C. DEVELOPMENT REVIEW

On the basis of the application, plans, reports and other information submitted by the applicant; findings and recommendations contained in the Planning Board Report for the public hearing on October 25, 2016 for application 2016-120 relevant to the site plan regulations; and the testimony presented at the Planning Board hearing, the Planning Board finds that the plan is/is not in conformance with the site plan standards of the land use code, subject to the following conditions of approval that must be met prior to the issuance of a building permit, unless otherwise stated:

3 SIDEWALK RAMP DETECTABLE WARNING TILE AND APEX RAMP
NOT TO SCALE

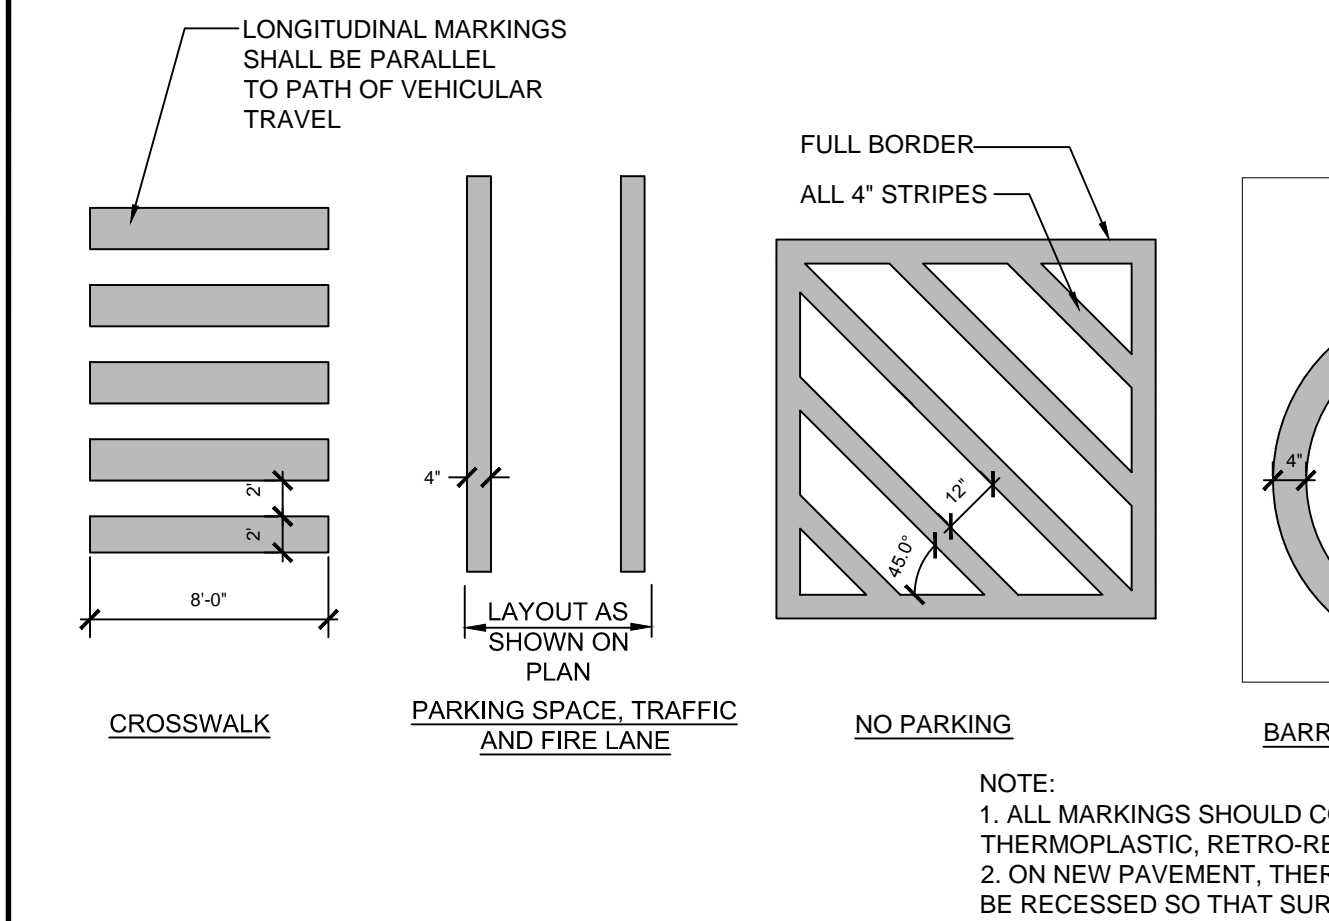
2. The applicant shall ~~submit~~have submitted final details for the reconstruction of the ramp on the south side of Hersey Street to meet ADA requirements~~for review and approval.~~ Said details shall have been reviewed and approved by the Department of Public Works; Said reconstruction shall be completed, approved, and accepted by the Department of Public Works prior to issuance of a Certificate of Occupancy.
